From: Katie Kurek [redacted]
Sent: 04 January 2019 11:20
To: Simon Davis <Simon.Davis@arun.gov.uk>
Subject: RE: WSCC Planning Consultations on AL/116/18/PL and AL/117/18/PL

I write in relation to the further requests from WSCC in respect of filed plan SP01 Rev B. I attach the architect's amended version SP01 Rev D for yours/WSCC's consideration. As before, if accepted, this plan will need to replace the reference in the filed application to plan SP01 Rev B.

C/No. 215818
O/No. 1/500 @ A2
SCALE
DRAWING NUMBER
SP01
DATE
10/16
REV D

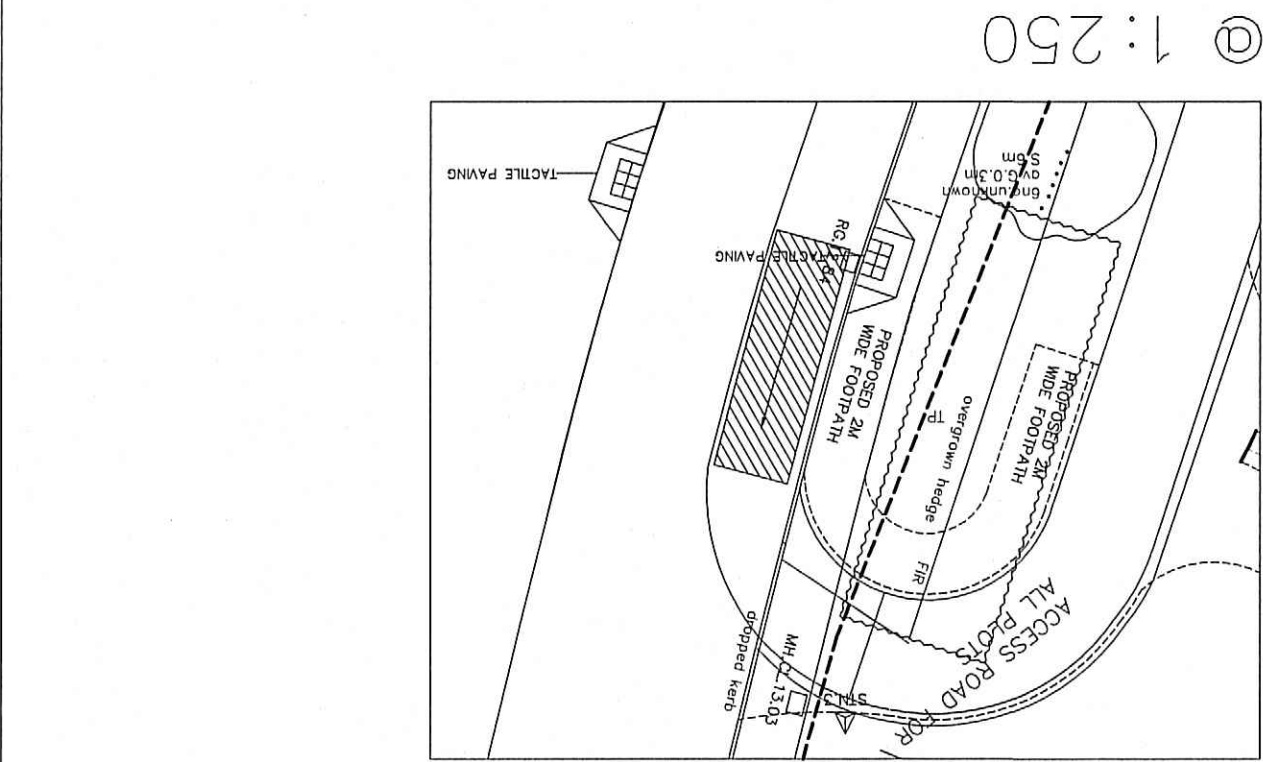
Provided that the splay shown passing through blue edged land can be maintained in perpetuity, the replacement with this plan is acceptable
